8 February 2013
GMA Ref: 275/2008

**SUBMISSION IN RESPECT OF PROPOSED MODIFICATION OF STATE
SIGNIFICANT DEVELOPMENT
23-37 LINDFIELD AVENUE & 11 HAVILAH LANE, LINDFIELD
MP08_0244 – MOD 1**

I refer to the subject application and on behalf of the adjoining property owners of land at 43 Lindfield Avenue, WZRM P/L, we hereby wish to make a formal objection to the modification application as proposed.

2 WEST ELEVATION
SCALE 1 : 250

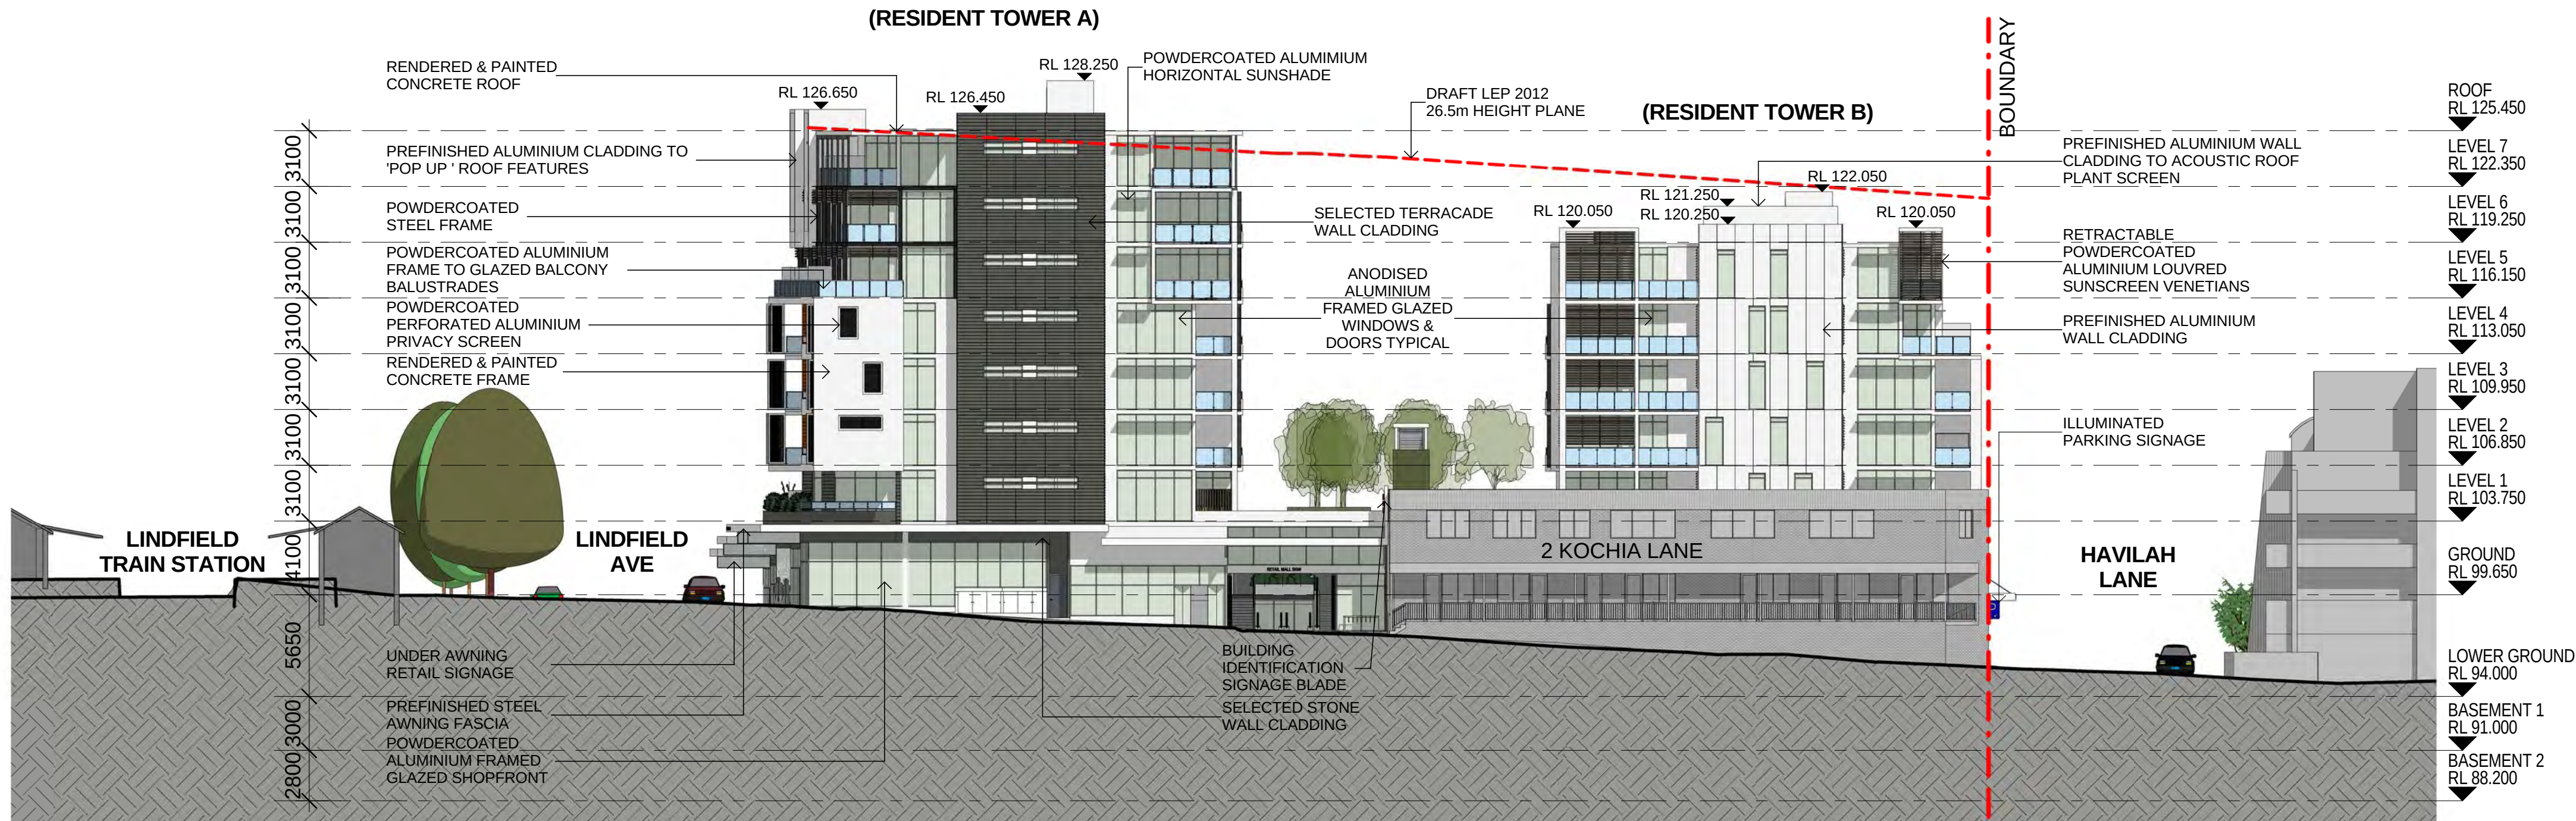
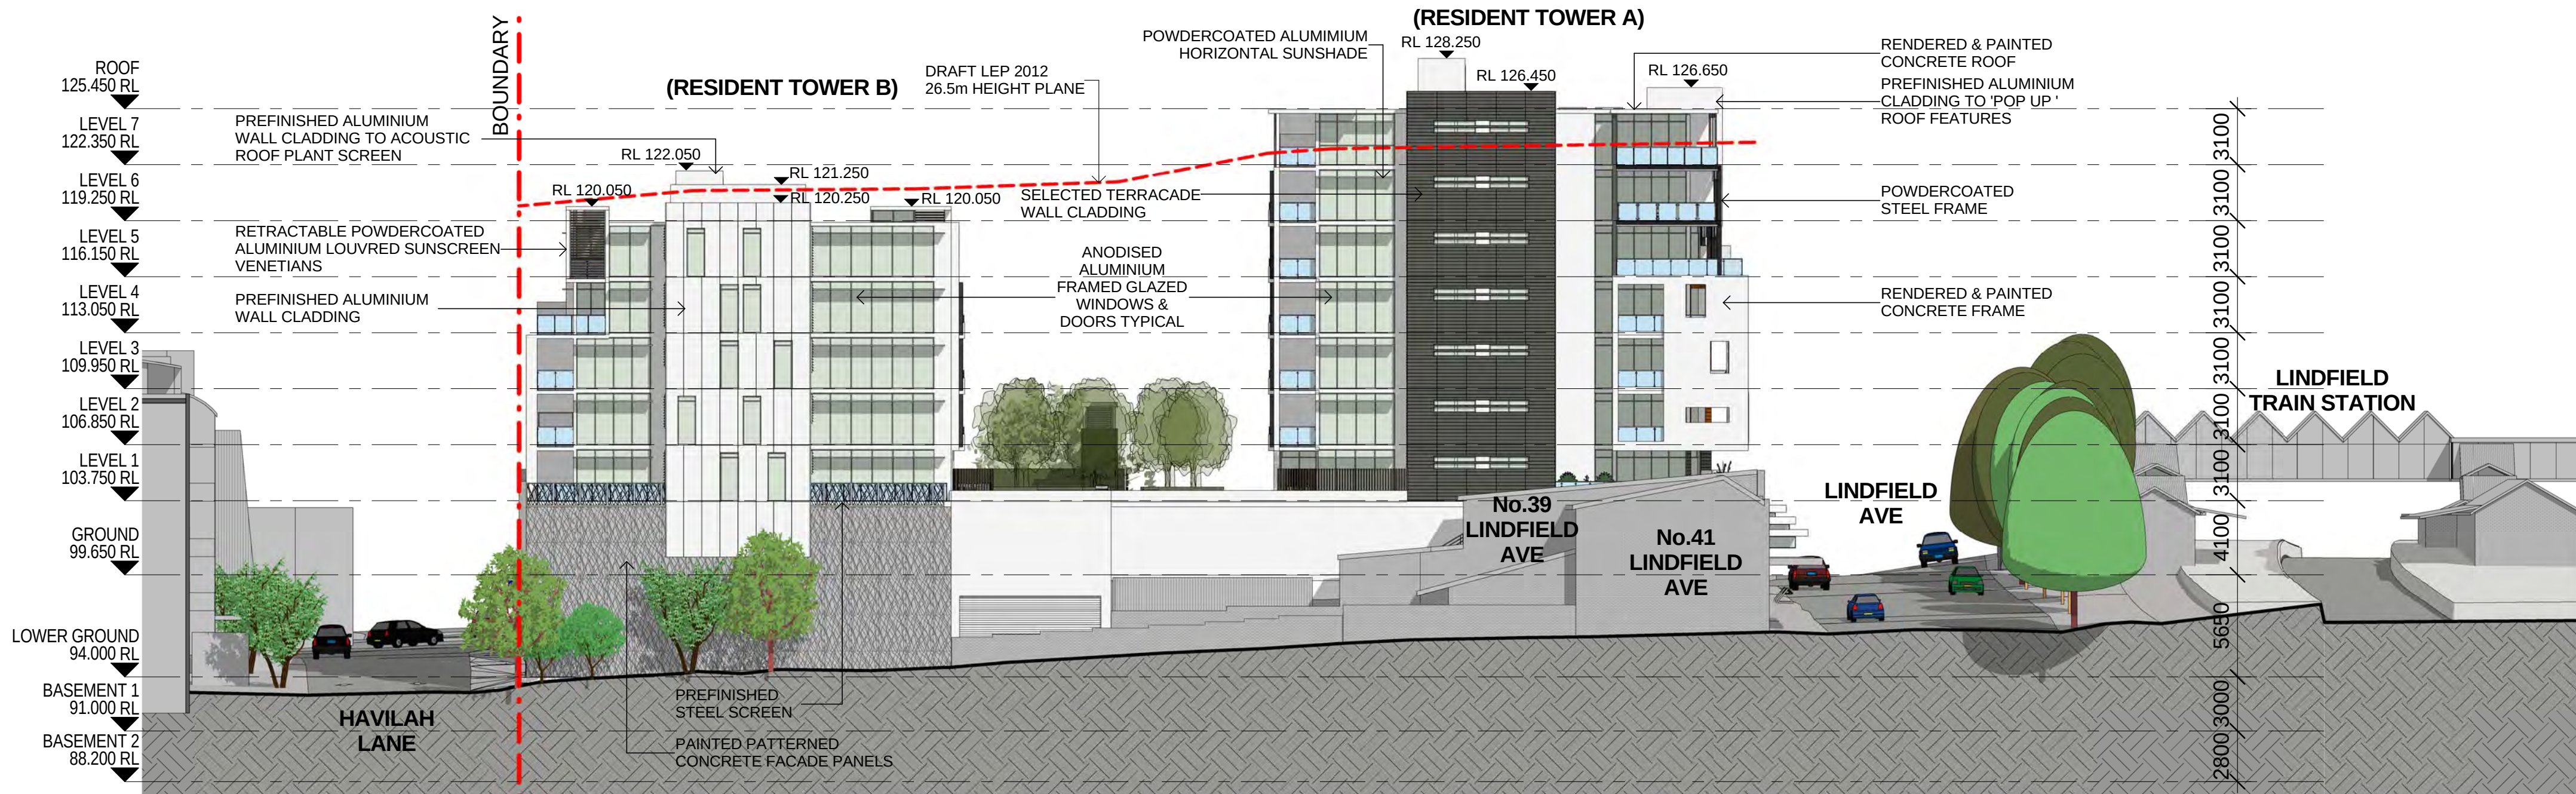
1. Location of Windows & Balconies in close proximity to the north western side boundaries of the site and the impacts of such an arrangement

- Windows to habitable rooms with a zero setback from the common boundary.
- Balconies with a zero setback to the common boundary
- Windows and balconies with setbacks of less than 3m from the common boundary and certainly less than 6m from the common boundary.

It is therefore submitted that the relationship of the proposed development to the north-western common boundary with the subject properties will result in unreasonable impacts upon the future development of those lands and should not be supported.

To this end it is requested that the applicant be required to demonstrate how the adjoining sites can be developed to their maximum potential having regard to the constraints and imposition caused by the inadequate and inappropriate setbacks which are proposed.

1 HAVILAH LA ELEVATION
2001 SCALE1 : 250

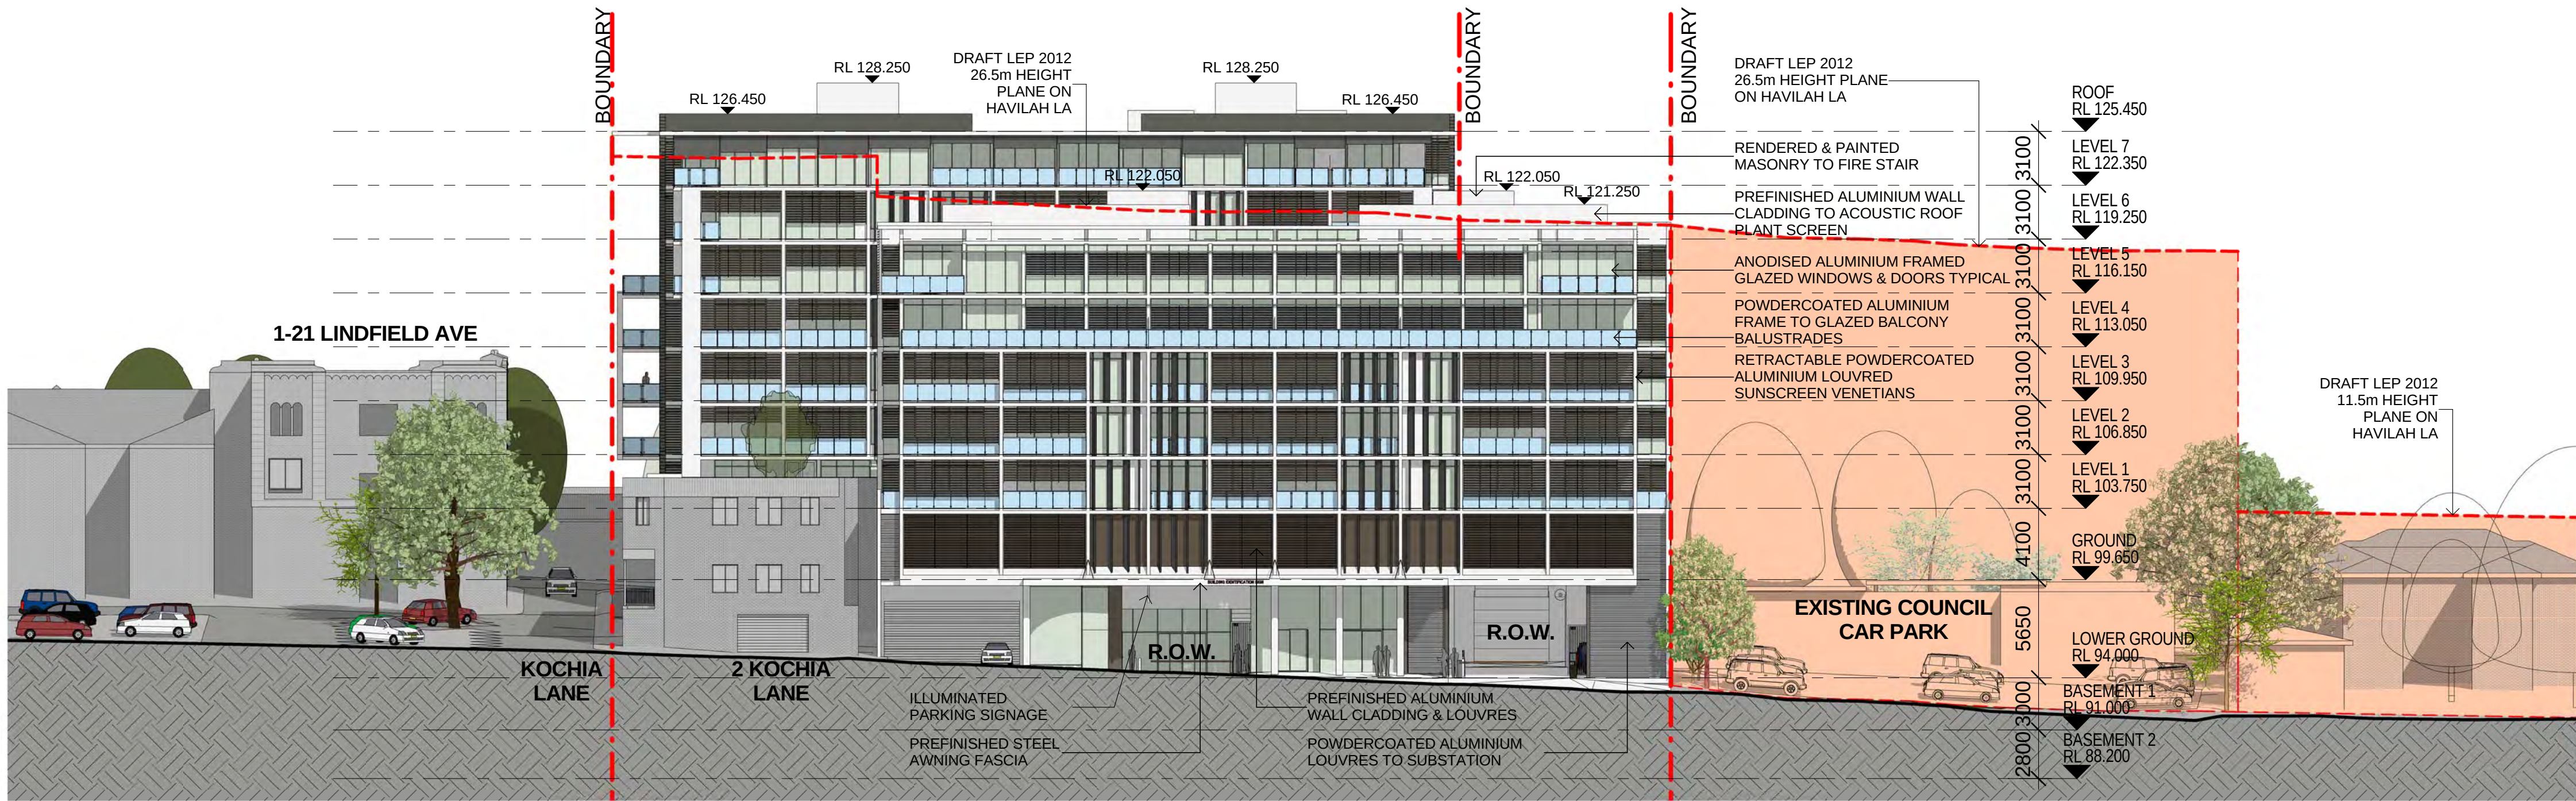
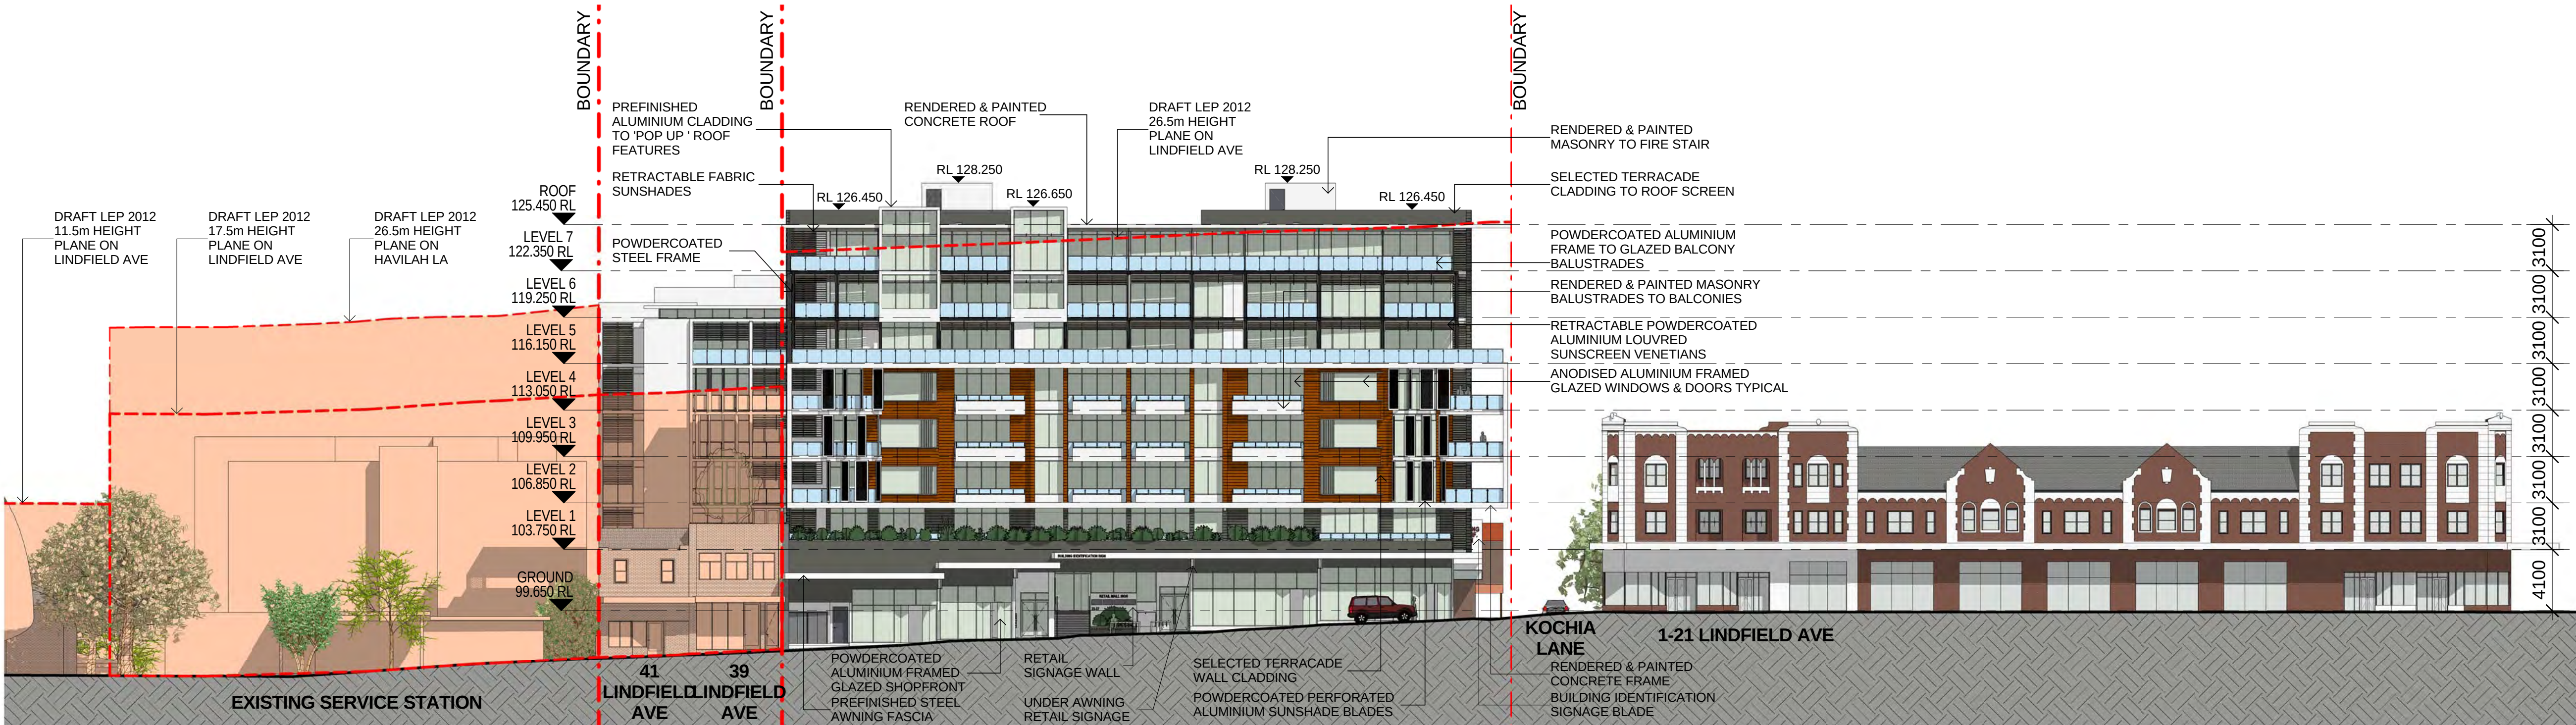
It is noted that the proposal provides for an increase in building heights of 4.28m in the case of Building A and 4.52m in the case of Building B.

In both cases the increase in the proposed building heights will provide for non-compliances with the Height Controls contained within the now adopted Ku-ring-gai Local Environmental Plan (Local Centres) 2012.

It is submitted that the proposal should be required to achieve compliance with the height controls required to be complied with by the adjoining sites.
